SSD-94006708 RESPONSE TO SUBMISSIONS COVER LETTER
PROPERTY AT 15-21 Cottonwood Crescent

Re: 88 Waterloo Road, Macquarie Park NSW

Specifically, this letter provides an overview of the amendments made to Appendix N Landscape Design Report and Drawings in response to the DPHI request for additional information on 25th May 2026 and relevant agency comments.

Table 1 – Response to Agency Comments DPHI Key Issues

● TREE RETENTION + REMOVAL PUBLIC DOMAIN & GROUND FLOOR

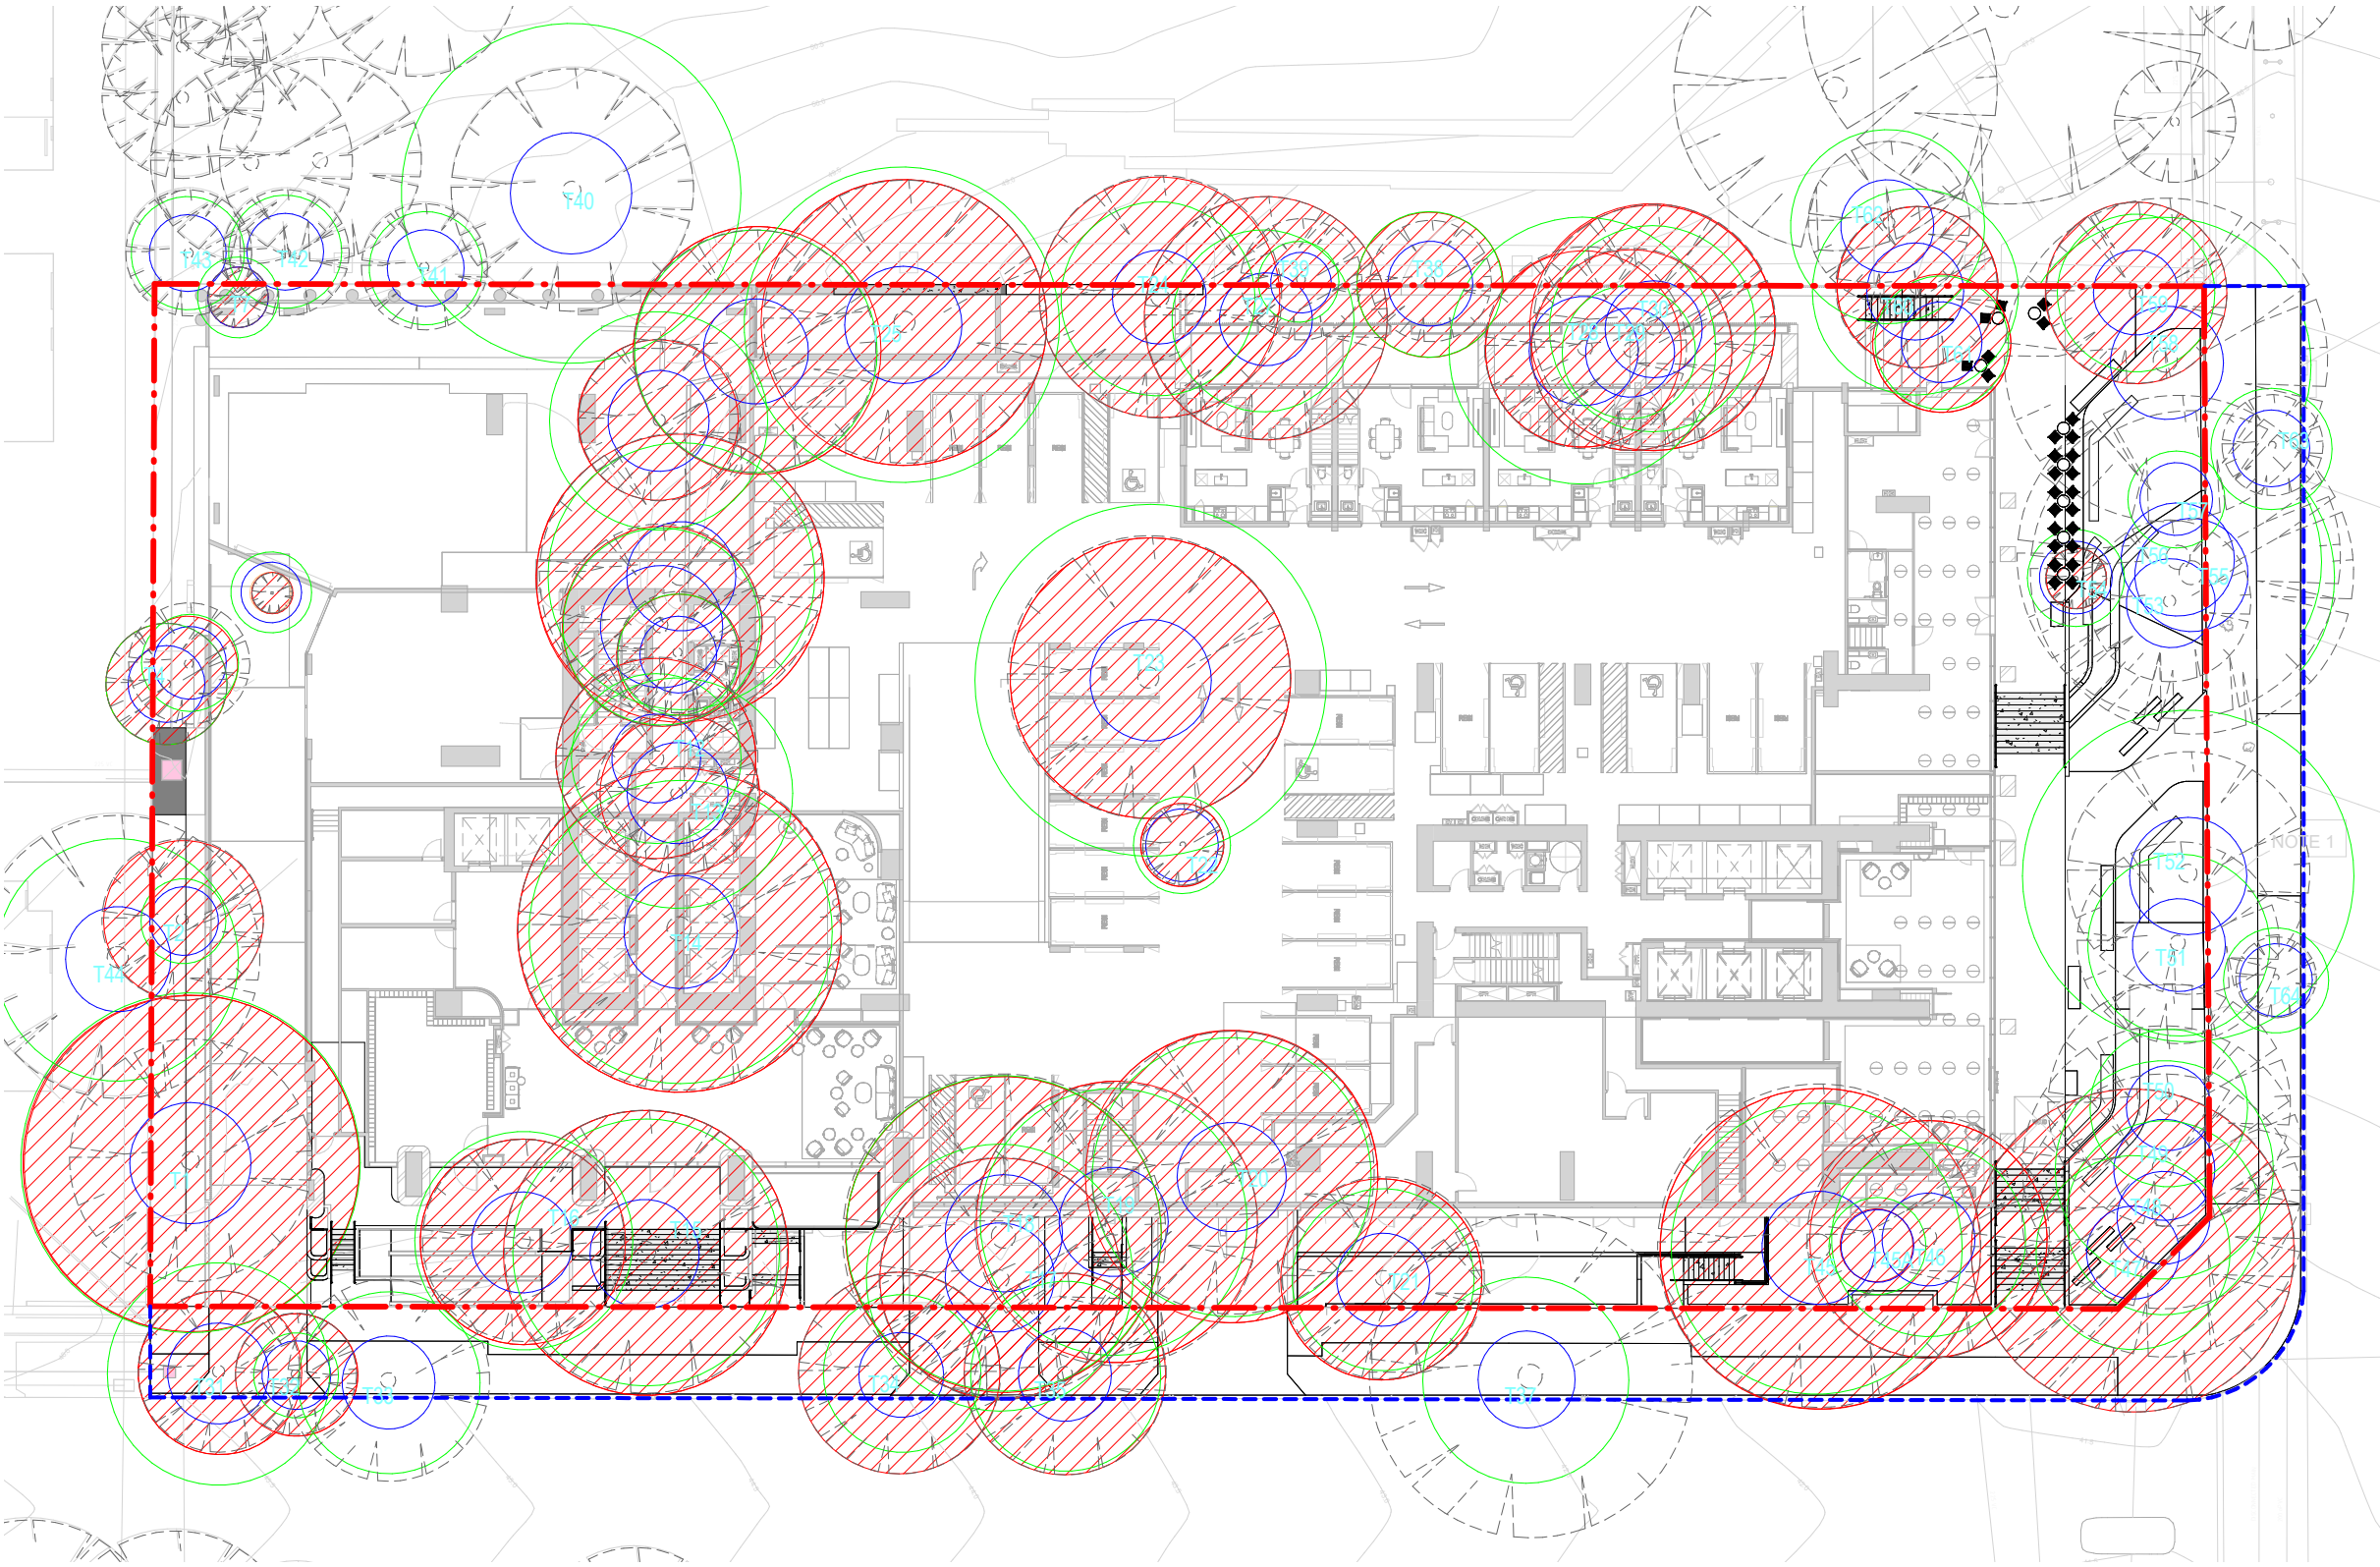
Refer Elevation JJ – Cottonwood Crescent – Page 43 of Design Report 
F	Tree retention: The subject site benefits from existing trees along Cottonwood Crescent, Waterloo Road and Elouera Reserve. These trees provide shade, natural screening and contribute to streetscape character. Of the 65 trees identified in the Arboricultural Impact Assessment, the proposal seeks to remove 49 of them. It is unclear why more trees , especially those located close to site boundaries or on adjoining land, cannot be retained. The retention of existing trees, supported by additional plantings and landscaping will help preserve streetscape	The podium setback to Elouera Reserve has been increased in localised areas to retain tree T41 along the boundary. The basement extent has been reduced along the southern boundary to retain T44. In conjunction with the arborist & civils we have reviewed the existing trees along Waterloo Road setback to retained additional trees from the original submission. The landscape re-design can retain additional trees T50, T64, T53, T57, T63 which were previously proposed for removal.	Refer Tree Management Plan – Page 21 of Design Report

Comments	Response	Reference
Tree Retention Existing mature trees along site boundaries currently provide shade and environmental value. The provided tree removal and retention plan indicates that most trees will be removed. All mature trees should be retained to the street edge at both Cottonwood Crescent and Waterloo Rd. Council requires a detailed arborist report for the removal of any existing mature trees.	The podium setback to Elouera Reserve has been increased in localised areas to retain tree T41 along the boundary. The basement extent has been reduced along the southern boundary to retain T44. In conjunction with the arborist & civils we have reviewed the existing trees along Waterloo Road setback to retained additional trees from the original submission. The landscape re-design can retain additional trees T50, T64, T53, T57, T63 which were previously proposed for removal. A detailed summary of the quality and value of the proposed trees for removal is shown on the tree management plan and within Arborist Report by Martin Peacock Tree Care Rev C dated 26.06.2026. 3 – High Value 16 – Medium Value 14 – Low Value 5 – Not suitable The previous scheme had proposed removal	Refer Tree Management Plan – Page 21 of Design Report

character and increase public domain amenity including along the interface to Elouera Reserve.	The two trees along Elouera Reserve which are being proposed for removal is due to the basement extent and constructability of shoring walls. T38 is classified as an exotic weed species under Ryde City Council tree list and Tree 39 is juvenile and can be replaced with a mature tree species as required to provide additional screening along the Elouera Reserve frontage. A detailed summary of the quality and value of the proposed trees for removal is shown on the tree management plan and within Arborist Report by Martin Peacock Tree Care Rev C dated 26.06.2026. 3 – High Value 16 – Medium Value 14 – Low Value 5 – Not suitable The previous scheme had proposed removal of 49 trees with the revised scheme proposing a removal of 45 trees (38 on site / 7 outside boundary in reserve / verge).	
--	---	---	--

of 49 trees with the revised scheme proposing a removal of 45 trees (38 on site / 7 outside boundary in reserve / verge).	
--	---	--

● LANDSCAPE MASTERPLAN PUBLIC DOMAIN & GROUND FLOOR

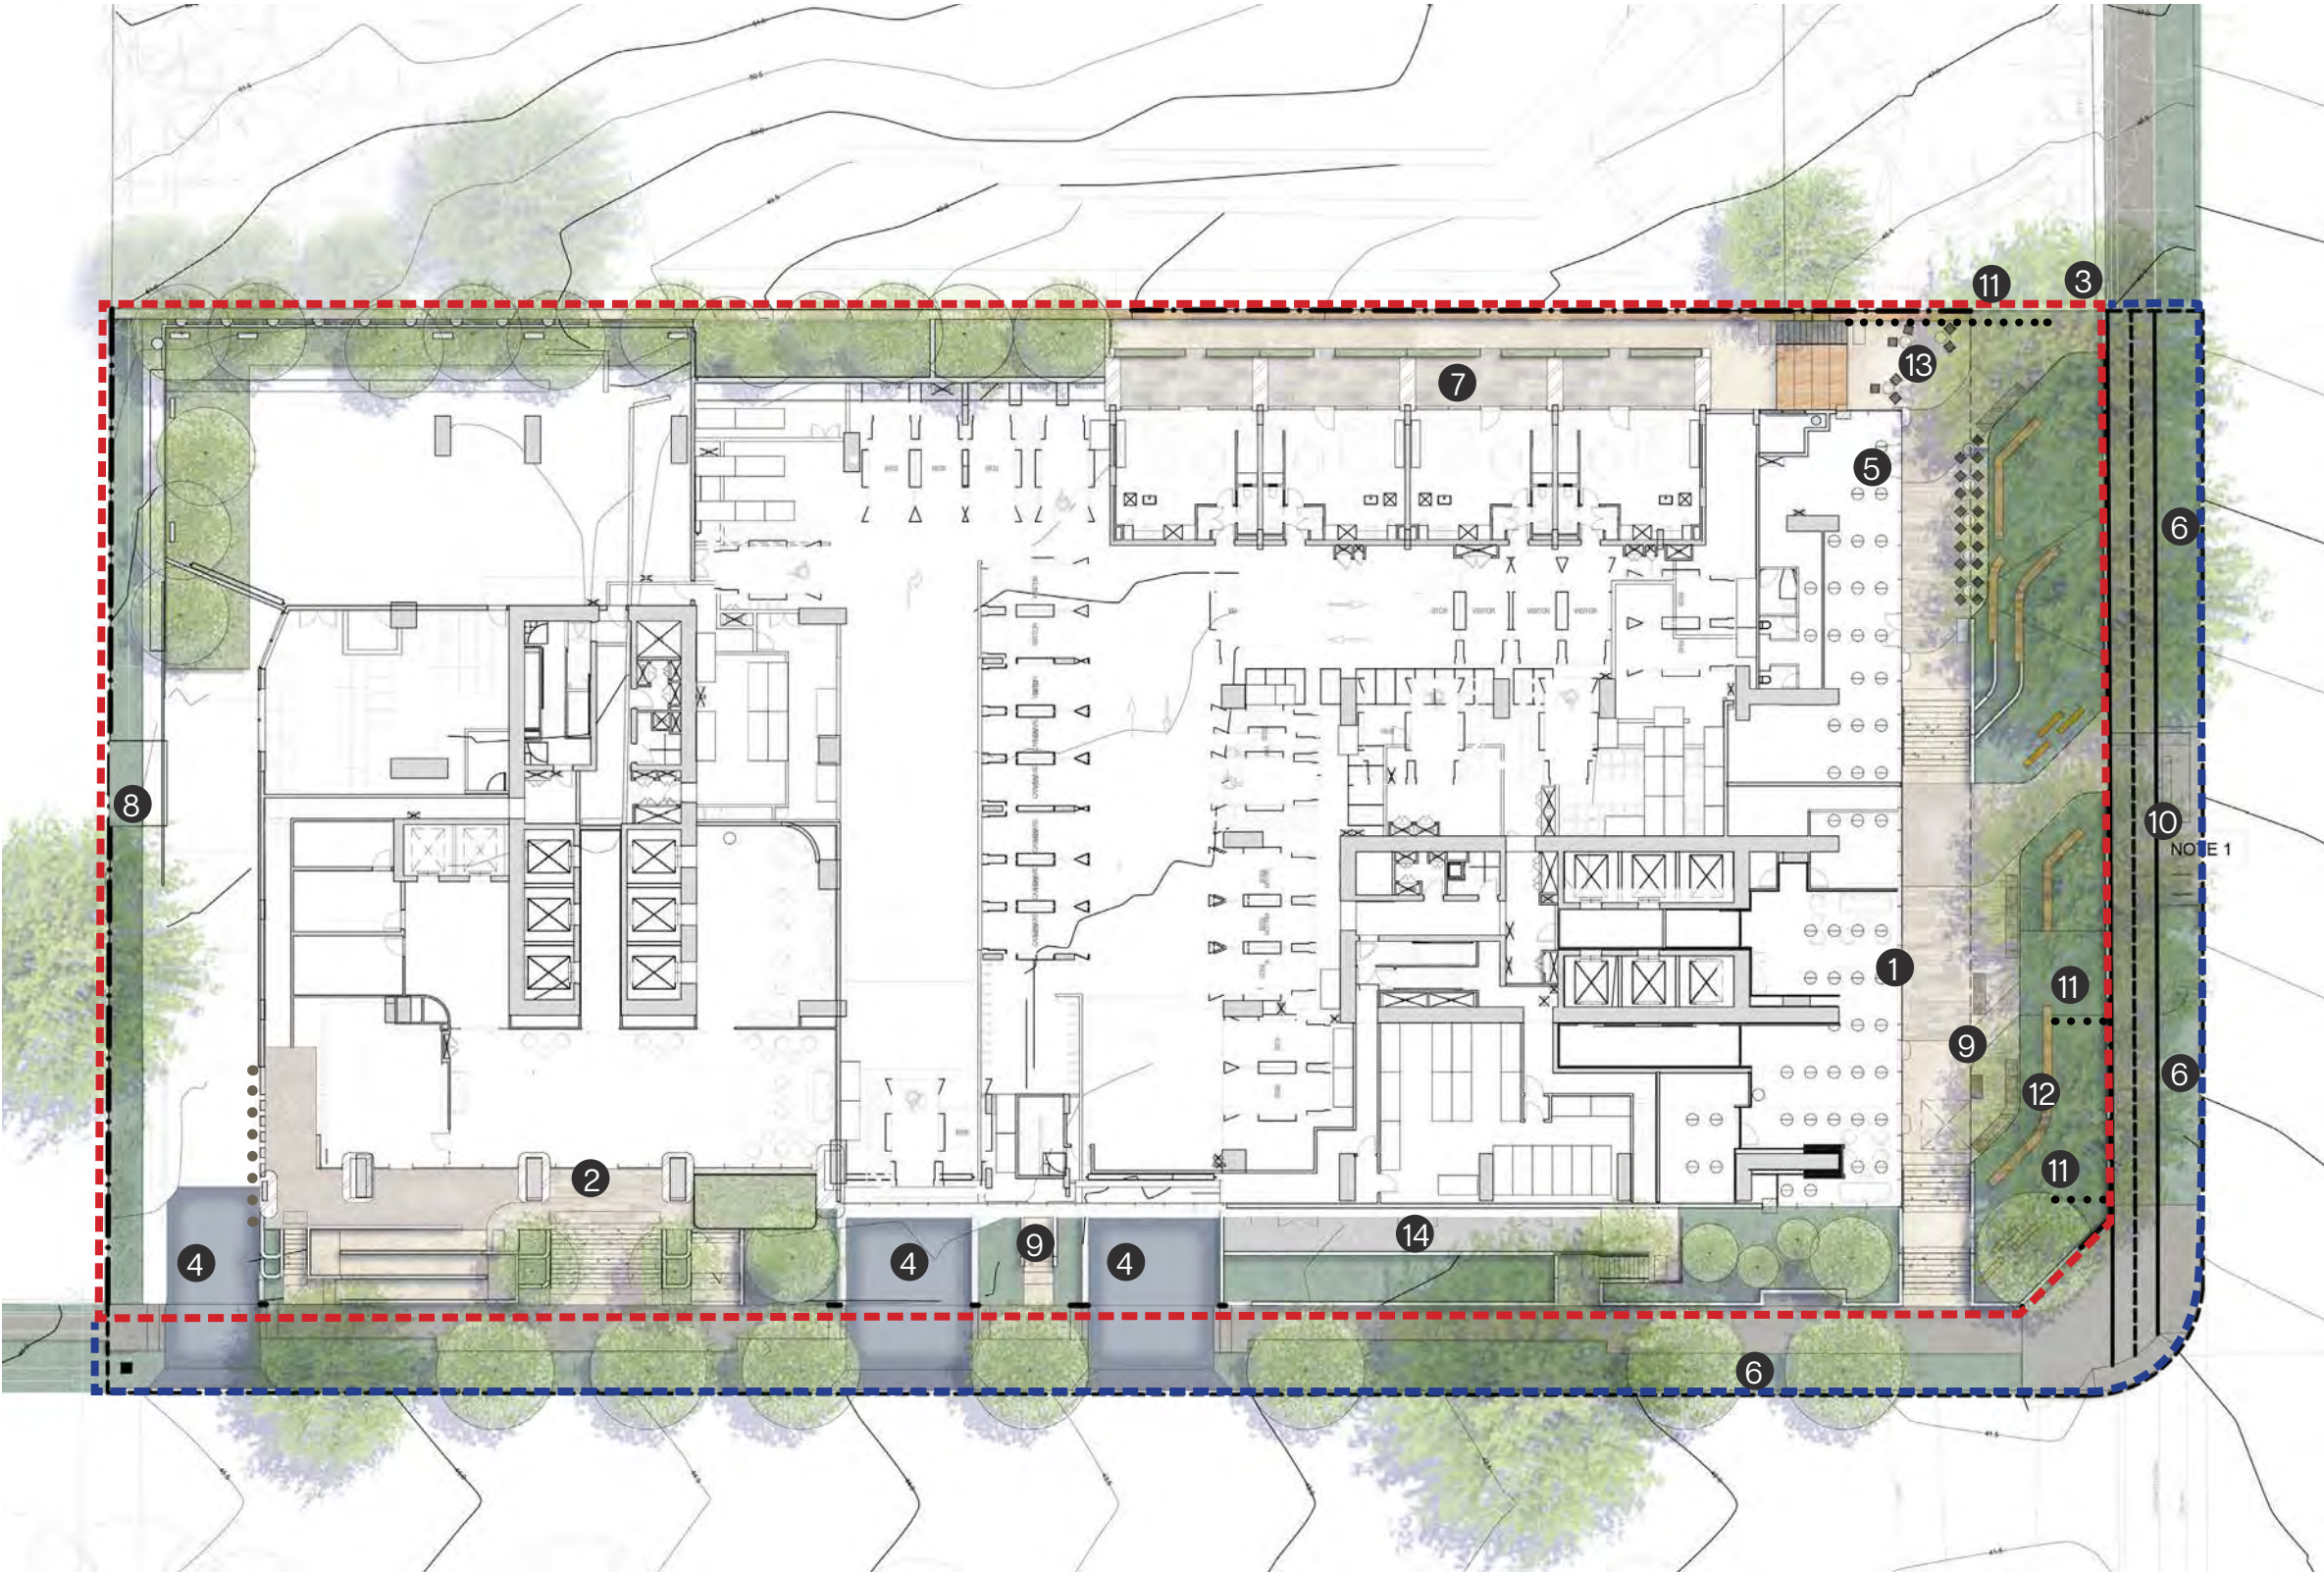
The accessible entry to the Waterloo Tower lobby is through an informal decked seating area. This does not present as a clear and legible main building entry. The design and location of accessibility points to main residential lobbies must be prioritised to establish a clear and publicly accessible street interface.

The re-design of the Waterloo Road interface to accommodate the changes to the retail provide accessible entry points which present as a clear and legible main building entry connecting to the publicly accessible street interface.

This is achieved through simplified wide pathways following the direction of travel along paved footpaths, supported on root bridge systems for areas within the existing tree TPZ zones.

Refer Landscape Masterplan – Page 26 of Design Report
